EA reference: PA-0013104/01
LPA reference: H17-0747-26

Date: 14 October 2026

**Proposed first floor extension to both incomplete dwelling and garage
15 The Reservoir, Surfleet, Spalding PE11 4DJ**

PROJECT: FIRST FLOOR EXTENSIONS
 ONTO EXISTING BUILDINGS
 SITE: 15, THE RESEVIOR,
 SURFLEET, Lincs.
 CLIENT:
 SCALES: 1:50, 1:100.
 DRAW NO: 15 RES 01-26

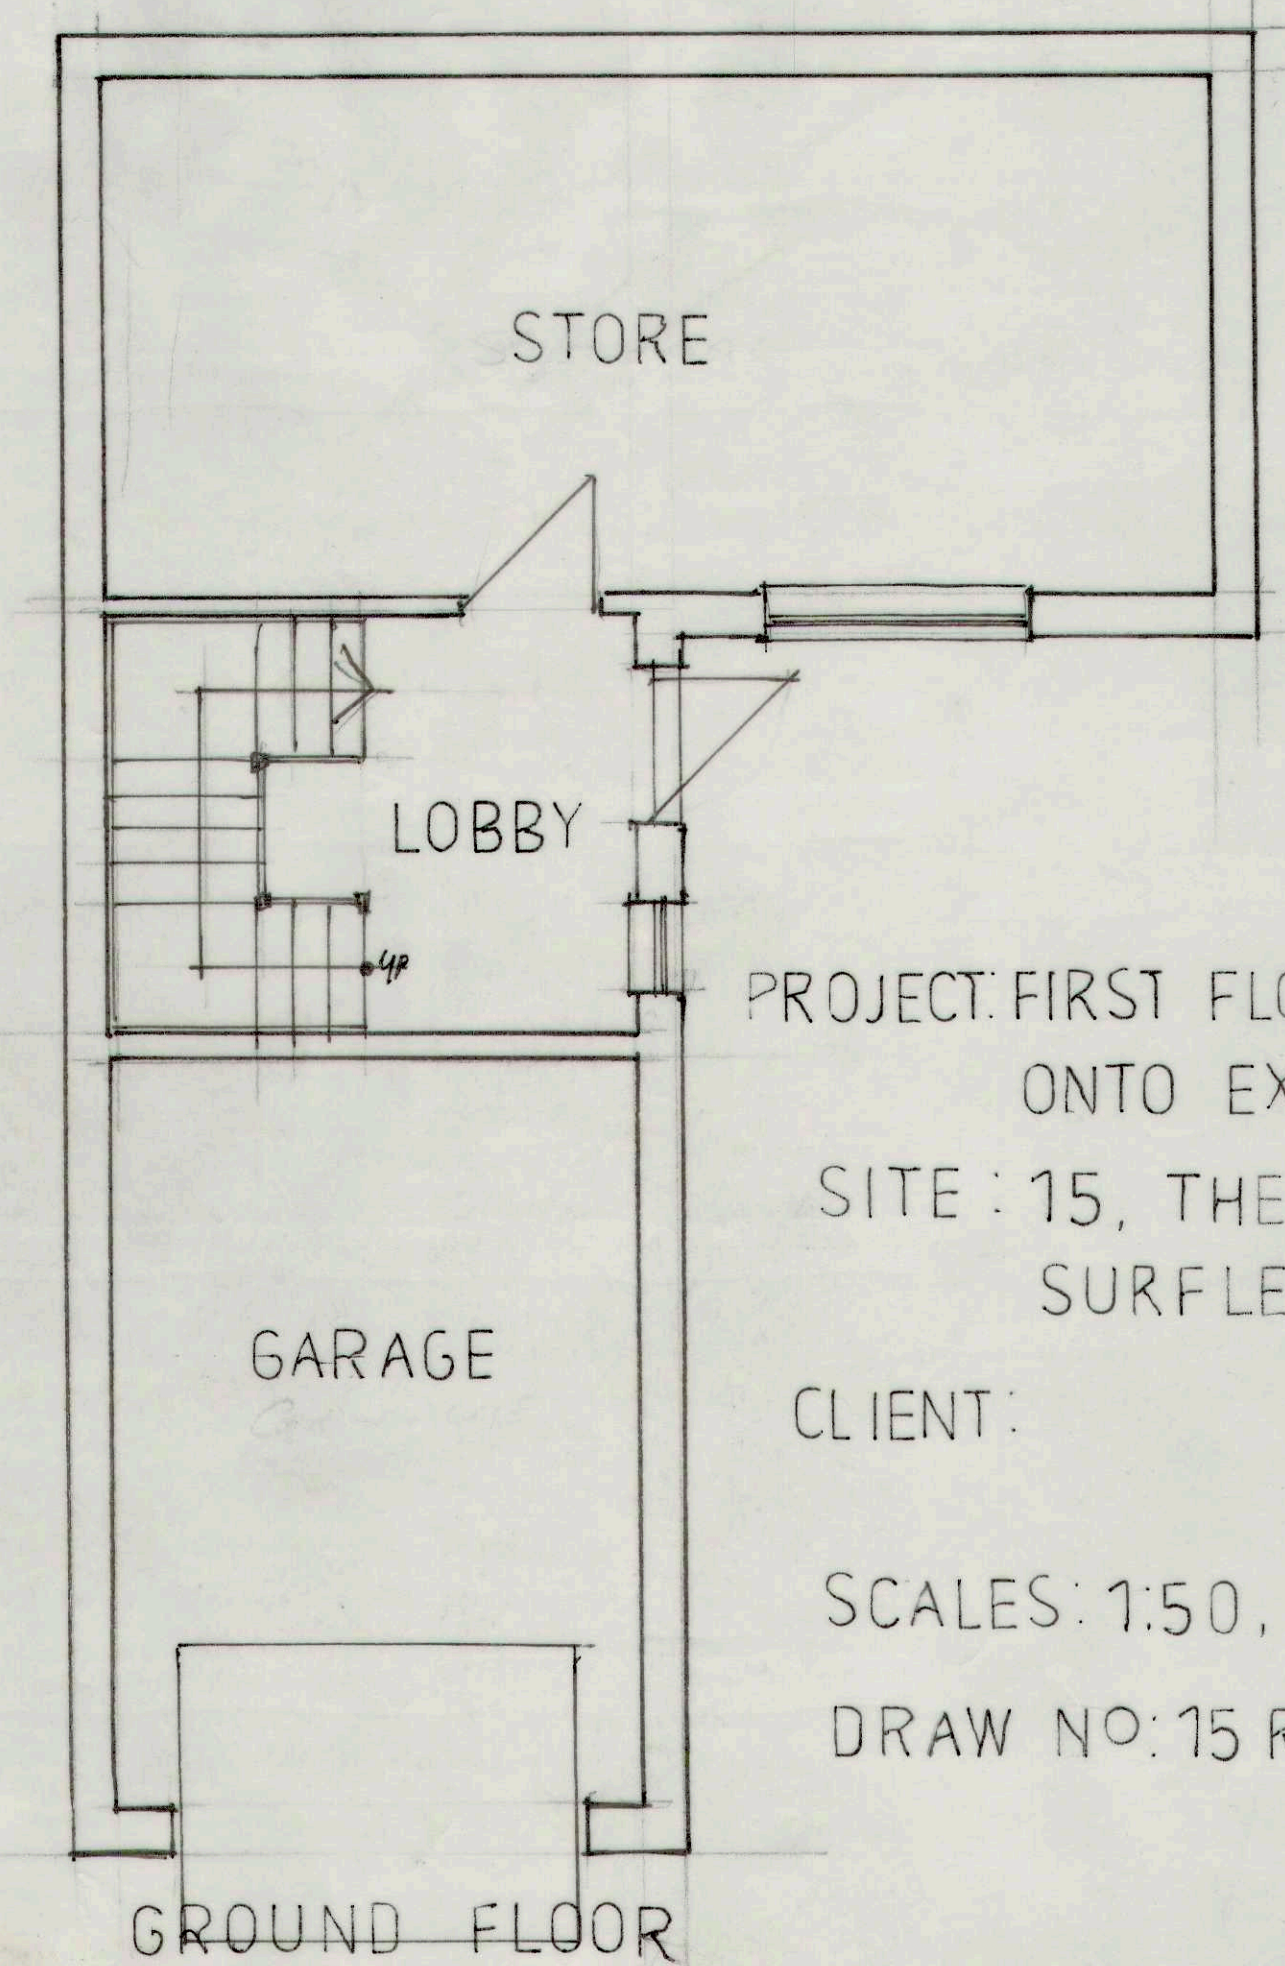
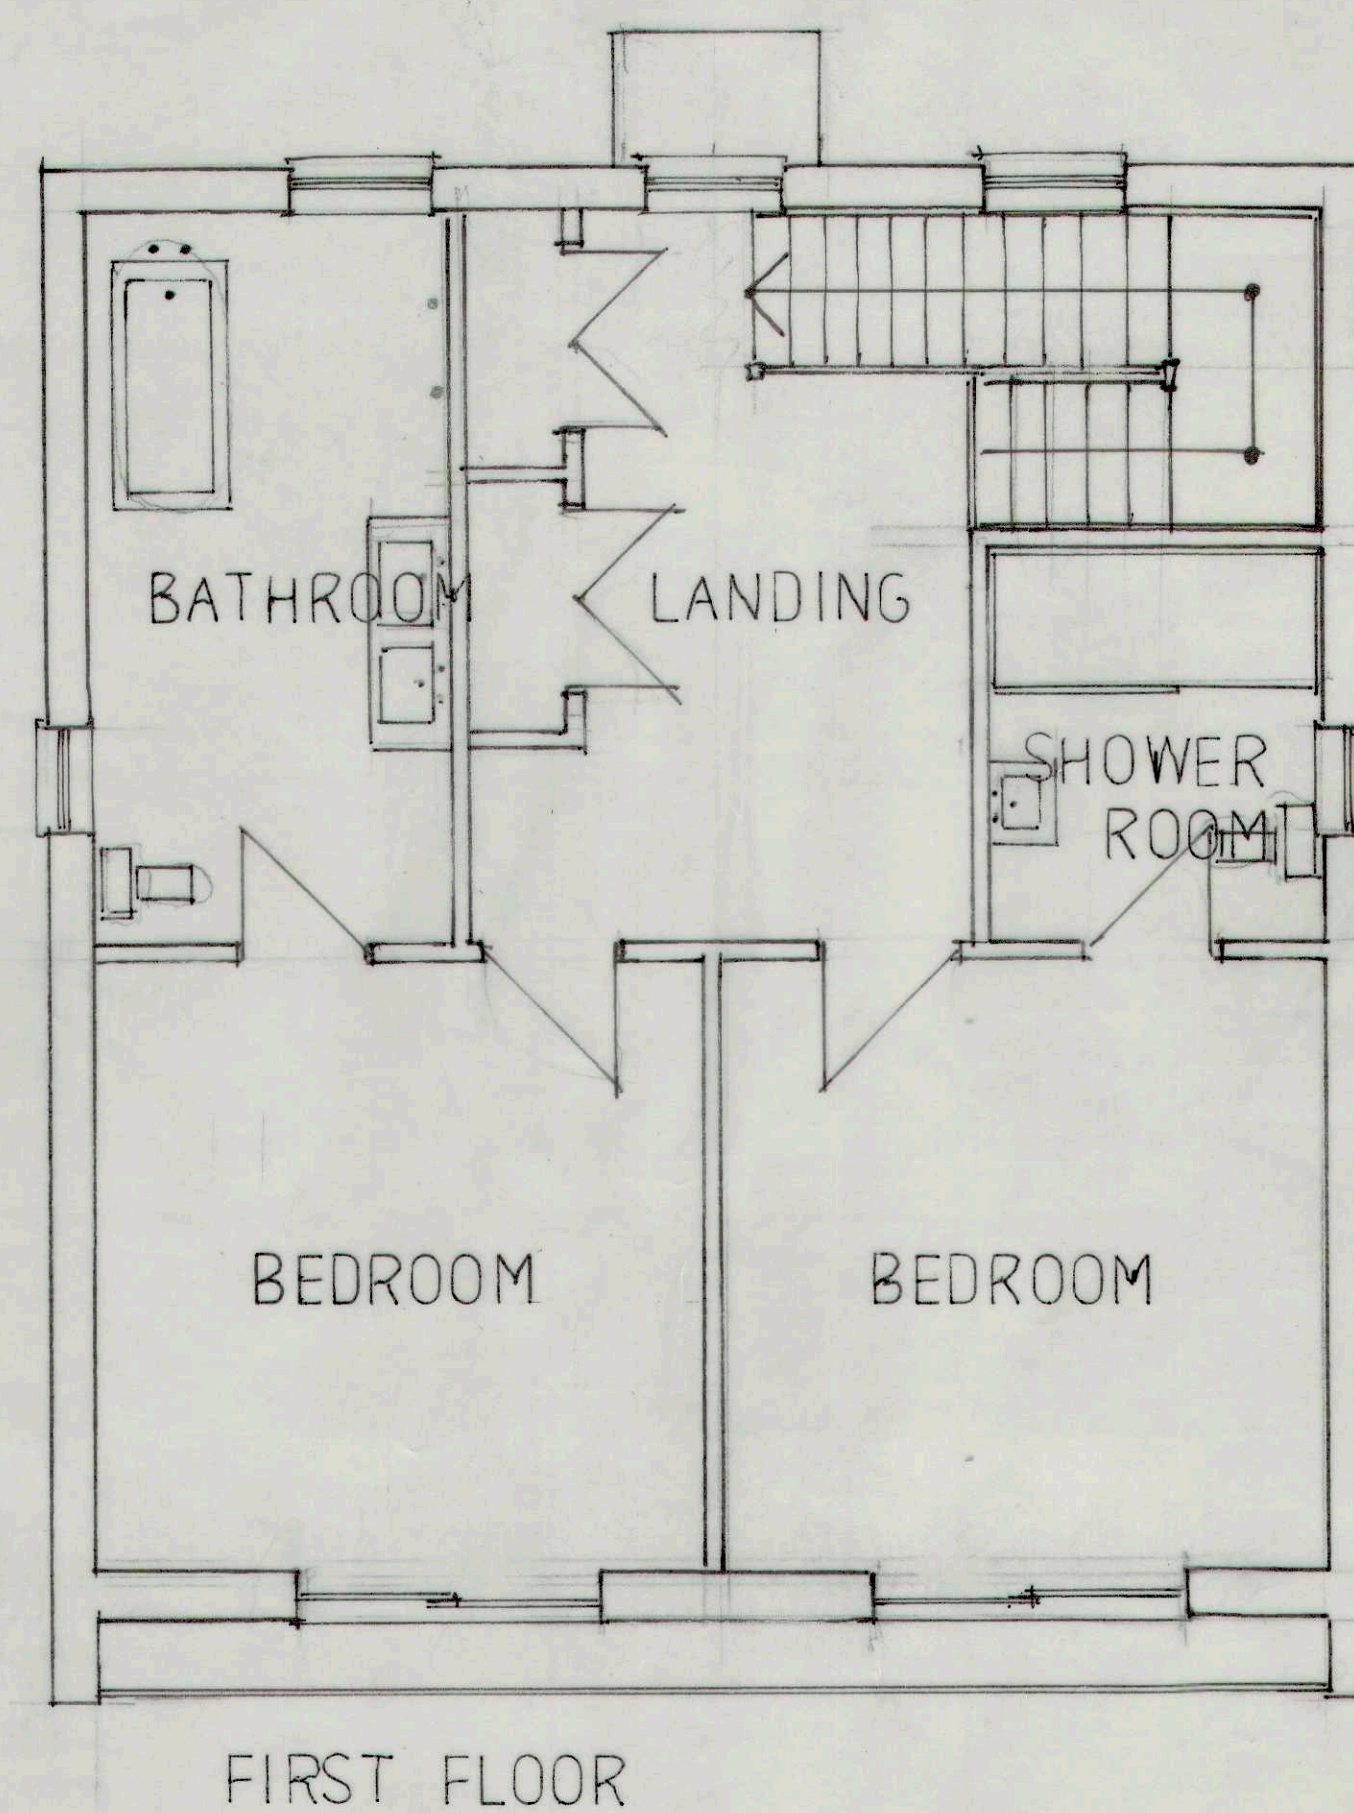
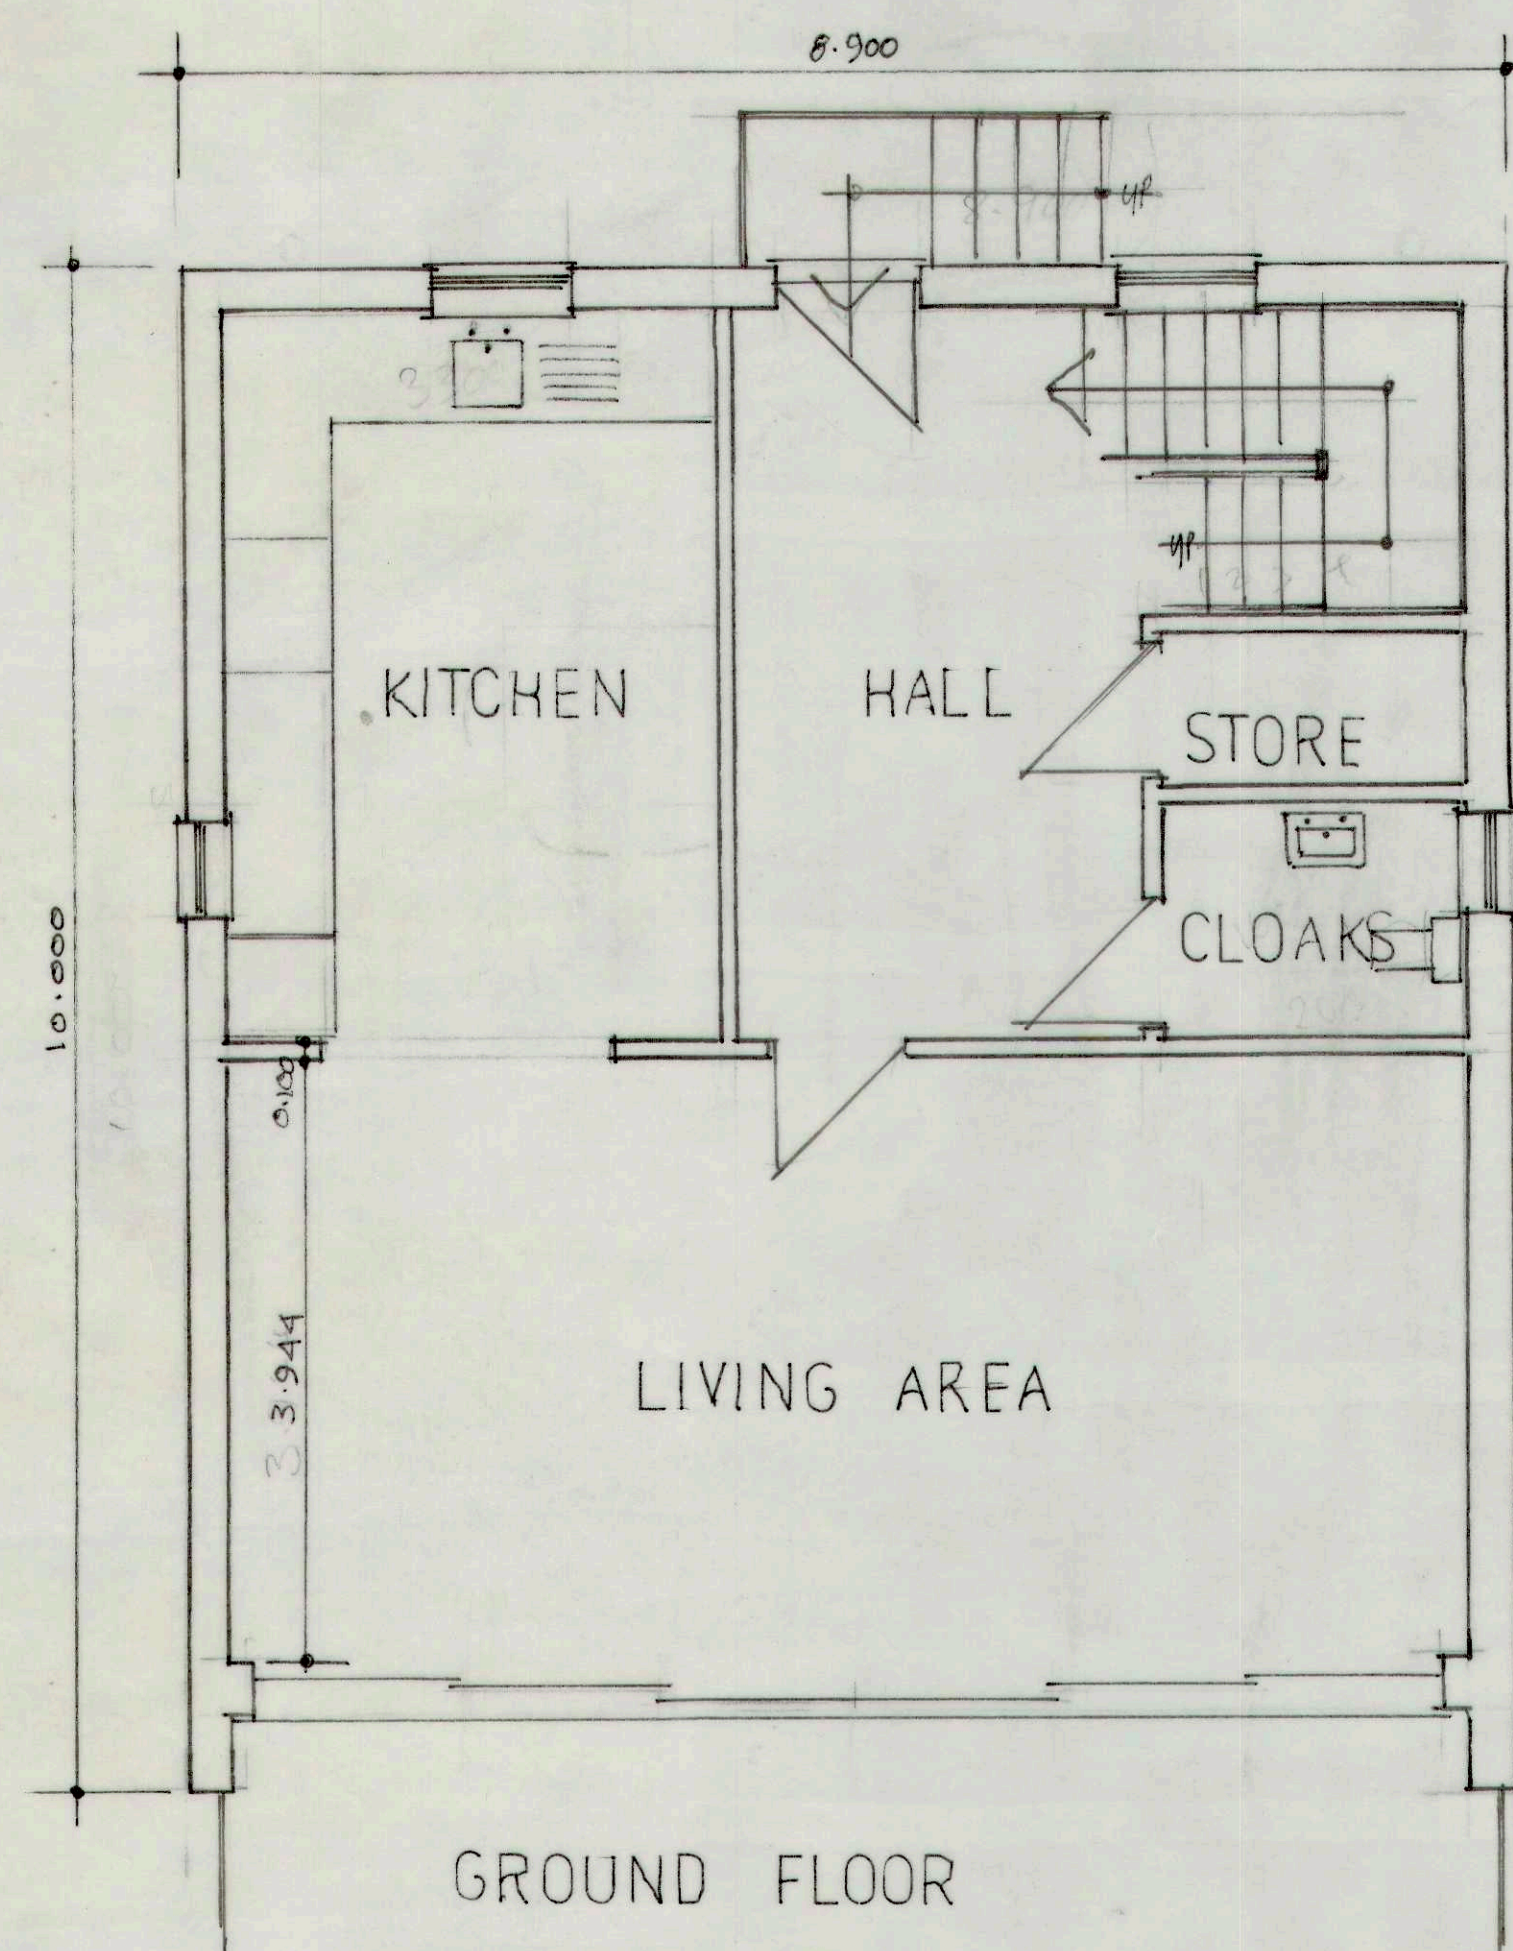
We note that the submitted elevation drawings do not show the inclusion of voids, however, as per the above, it is our understanding that the approval of elevation drawings under this application will not extinguish the requirement for the incomplete dwelling to comply with the flood risk requirements of permission H17-0216-21.
